MEMORANDUM

DATE: April 28, 2023
Response: October 4, 2024

SUBJECT: SF-23-007 – Waterbury Filing No. 1
First Submittal

Engineering Division

WATERBURY FILING NO. 1
CONSTRUCTION SET
WEST CHANNEL - CHANNEL IMPROVEMENTS PLAN

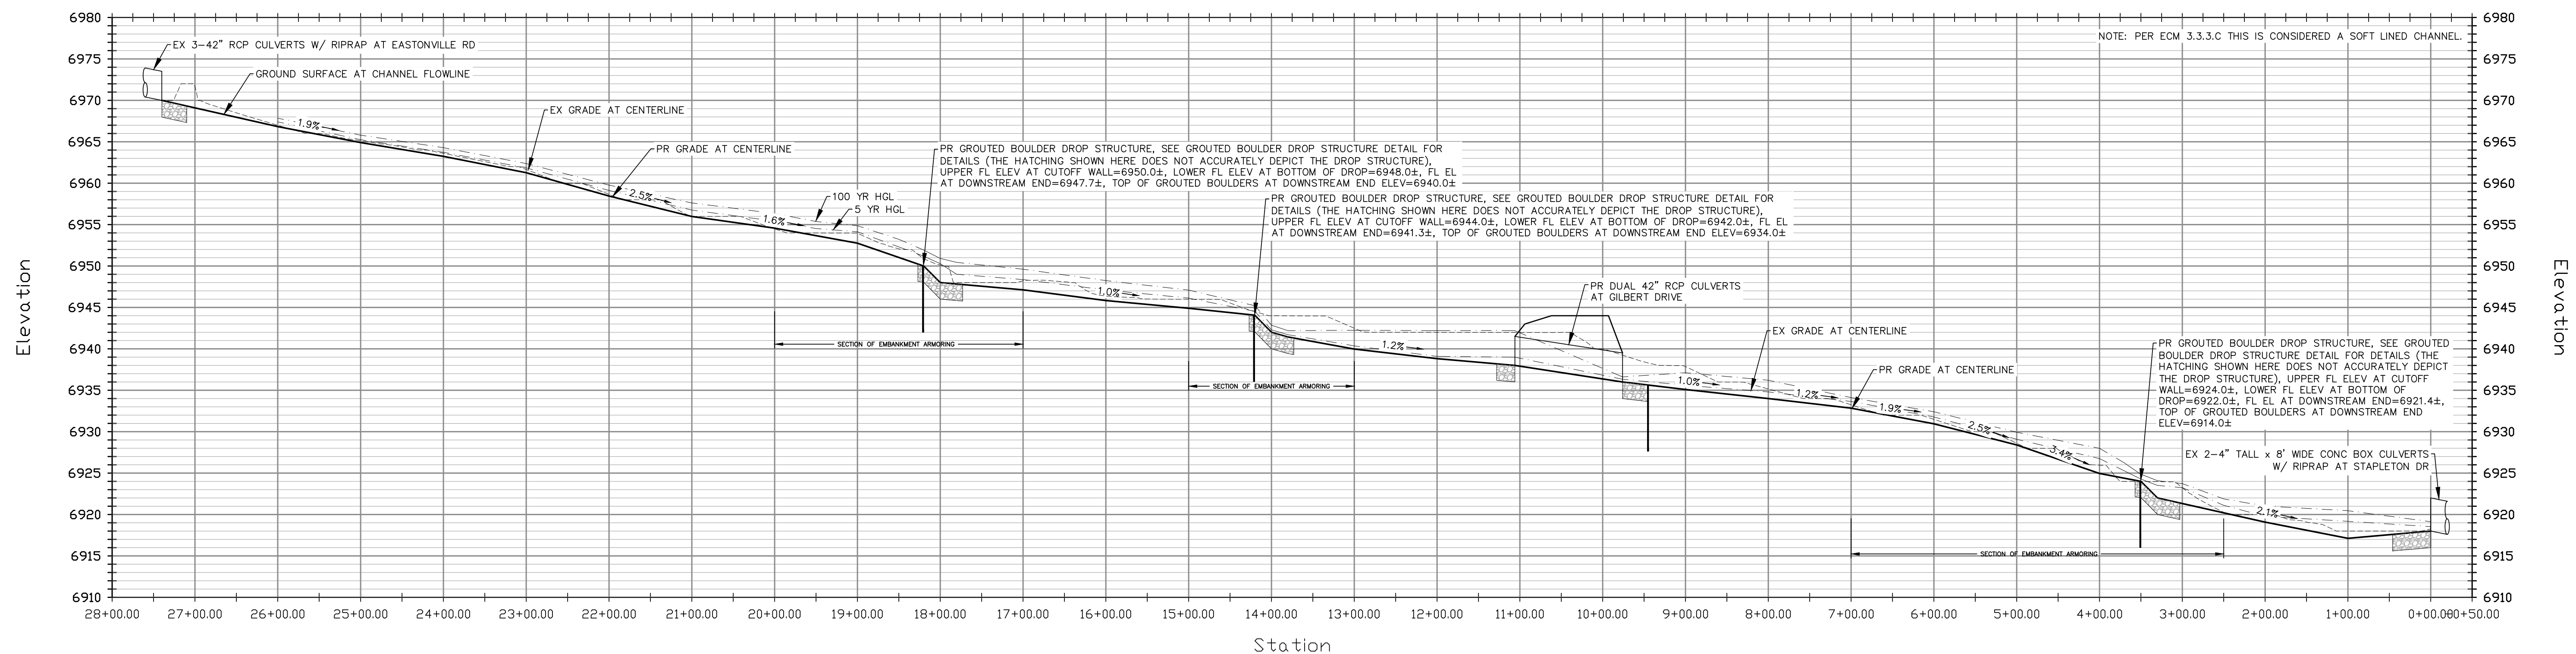
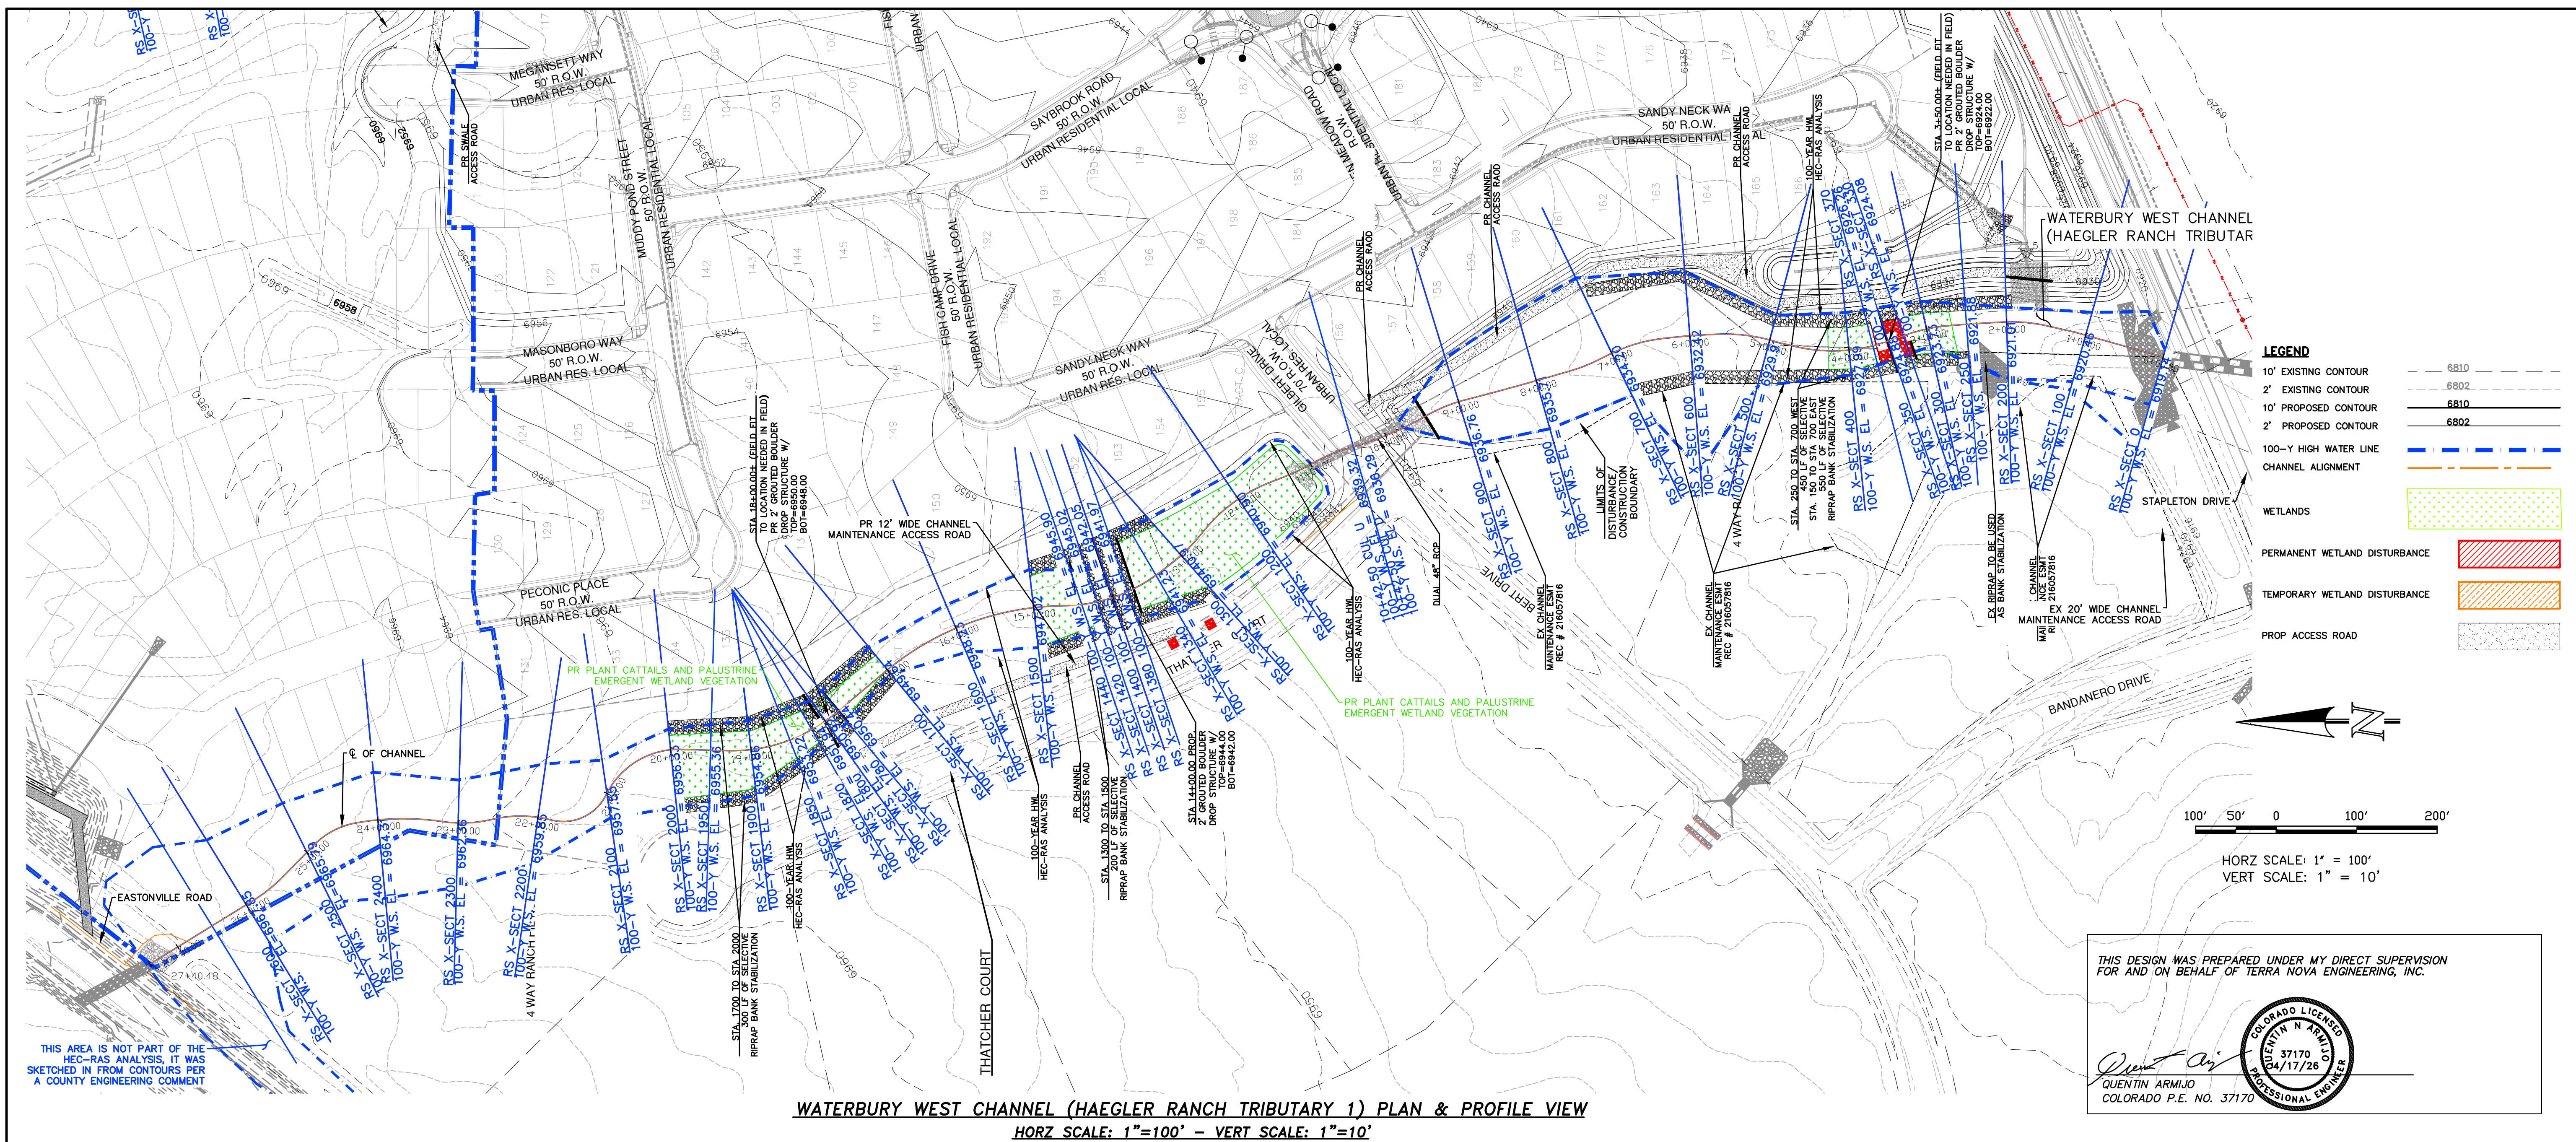
1. See FDR redlines. Done
2. Provide detailed channel stability analyses for each channel and swale:
 - a. Supercritical flows have been identified in a few areas. Only have on west channel and we are adding channel bank armoring plans at end of CD set. Address how the channels will be stabilized or modified to meet criteria. Detailed analysis is required with the FDR and channel plans.

- b. Provide channel plan and profiles adjacent to the subject property to highlight the areas of concern that may need stabilization protection measures. Added channel bank armoring plans at end of CD set.

MINIMUM FINISHED FLOOR ELEVATIONS BASED 100-Y HWL

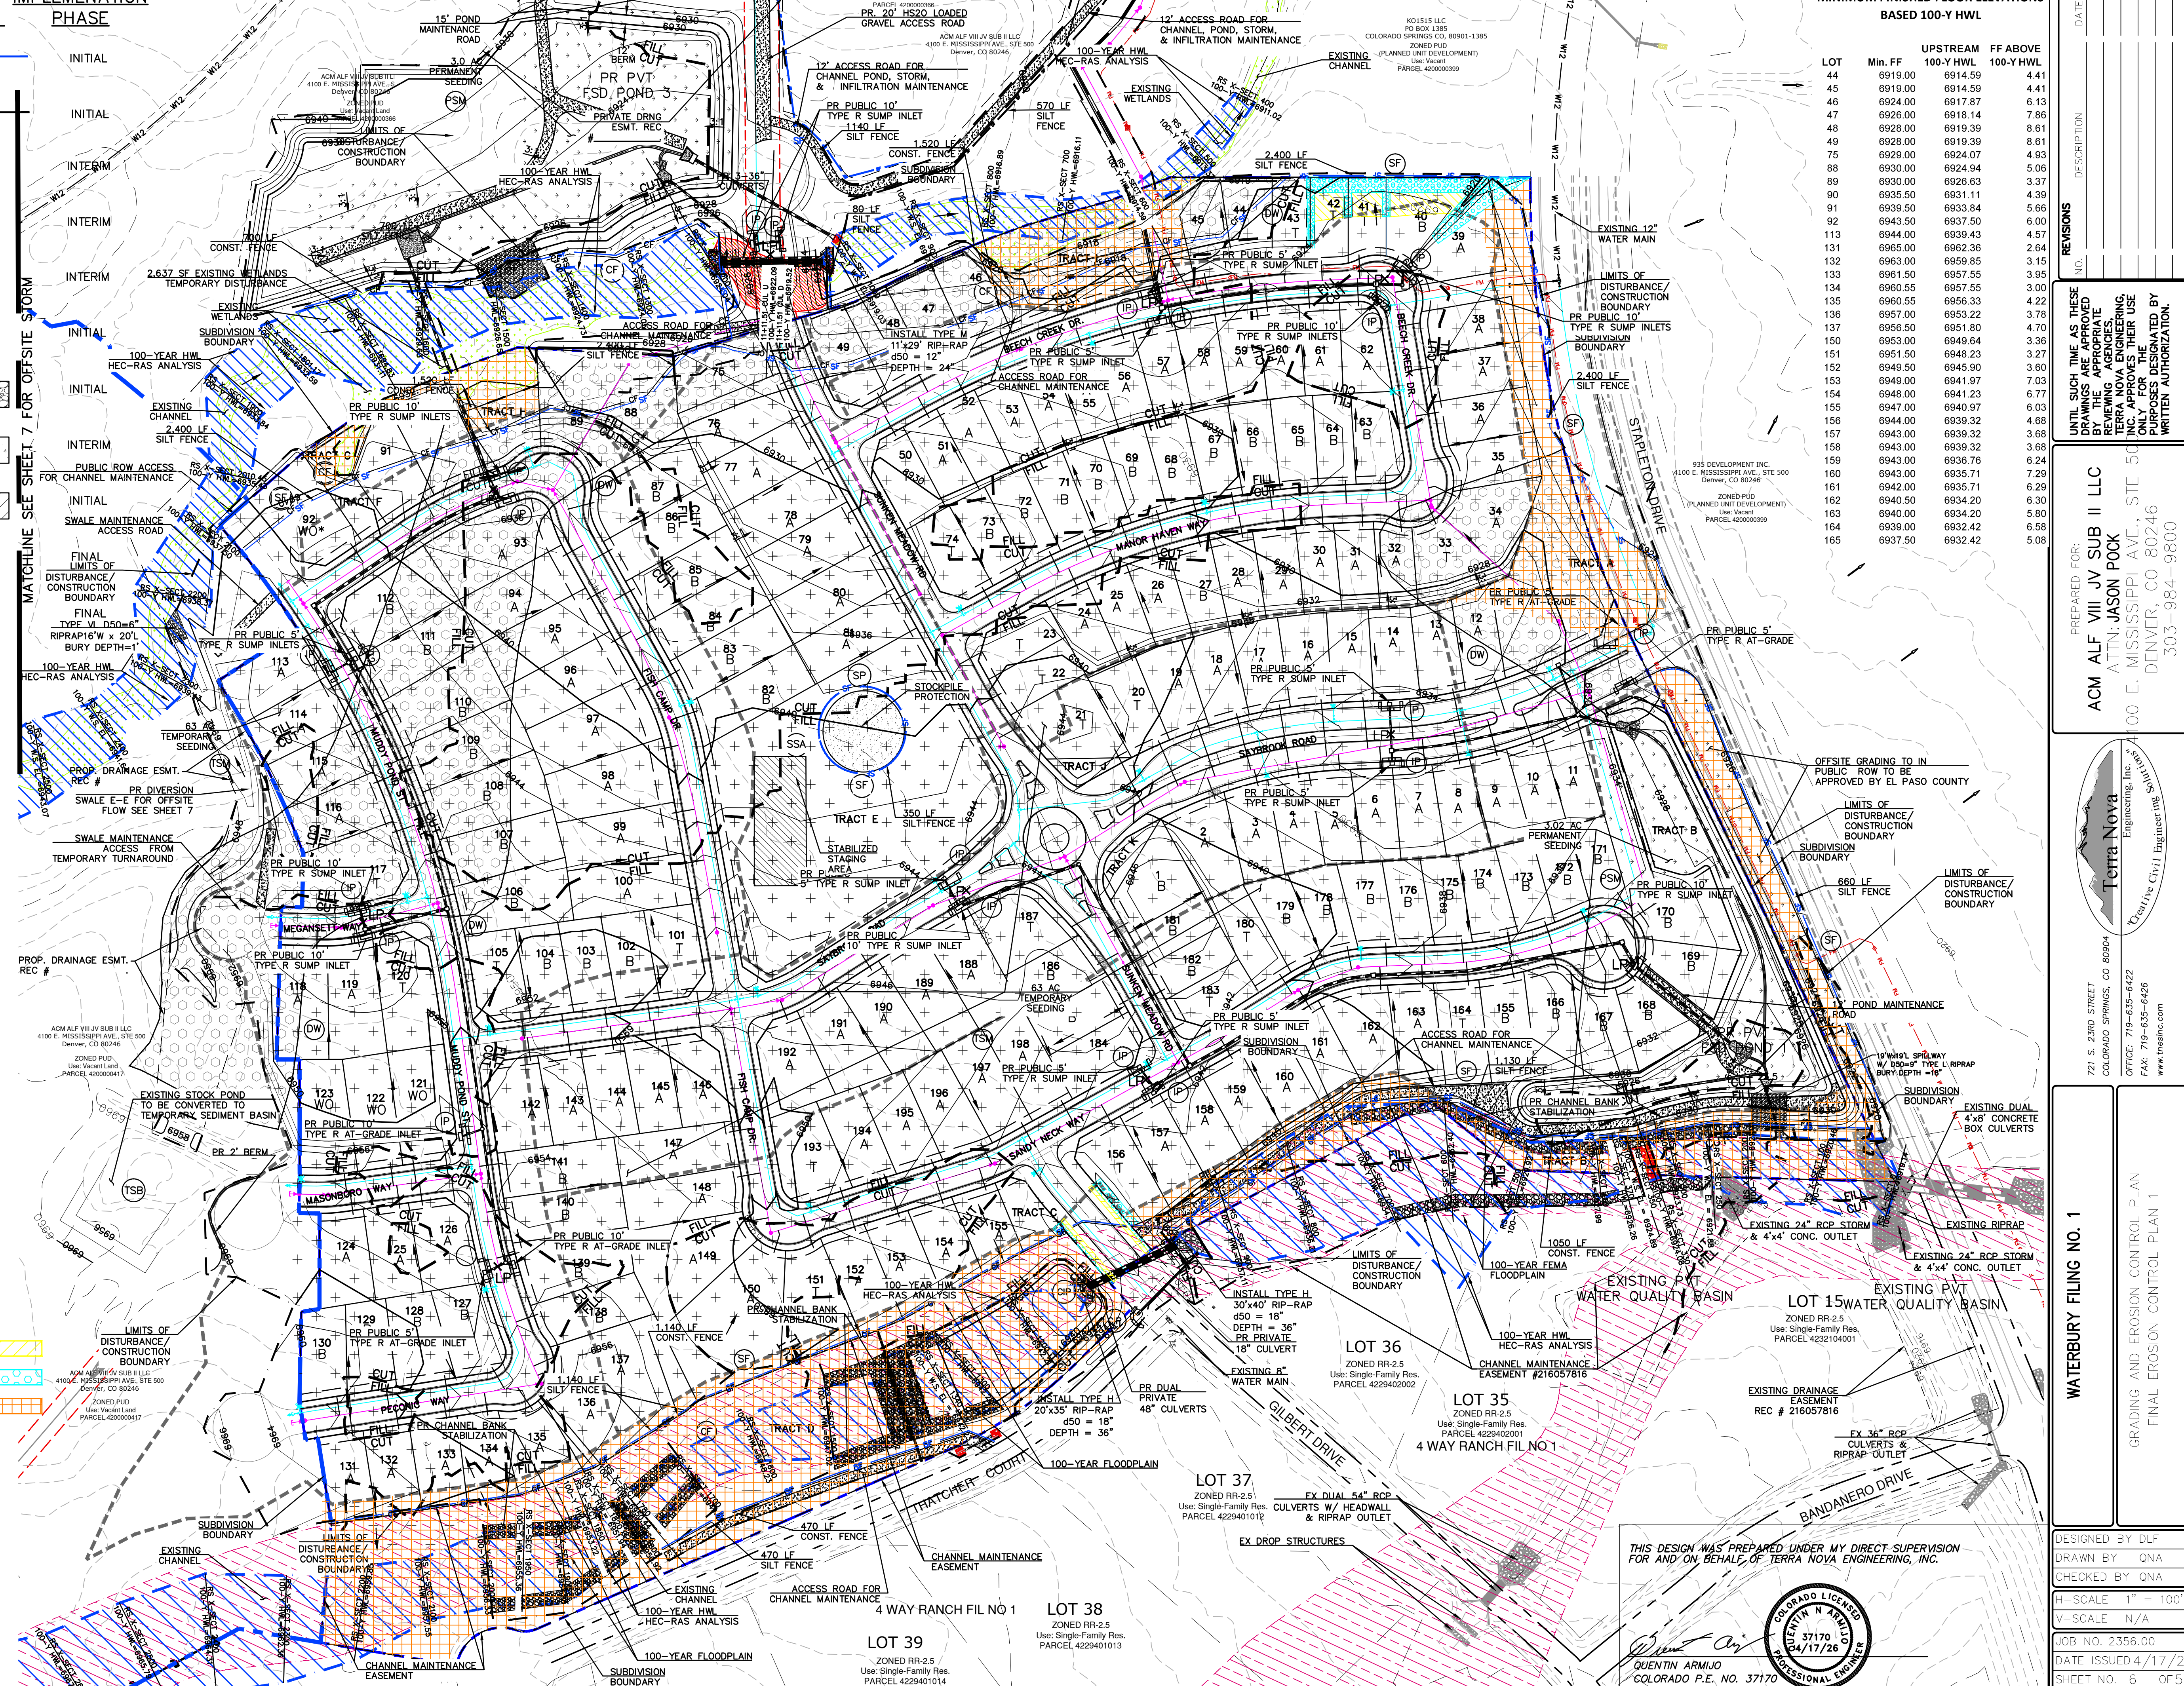
3. Label the minimum finished floor elevation on all lots adjacent to the drainage channels or provide a table with lot number and required elevation and survey Datum. **Done added table**
4. Previous comment from PUDSP: The Soils and Geology Report is acceptable for preliminary purposes; road and pavement design will be addressed with the final plats. Note: Additional groundwater testing will be needed at the final plat stage for verification of depths in the south area of the site (TBs 300-304). Provide all analysis needed for road, drainage, and embankment design. **Noted**
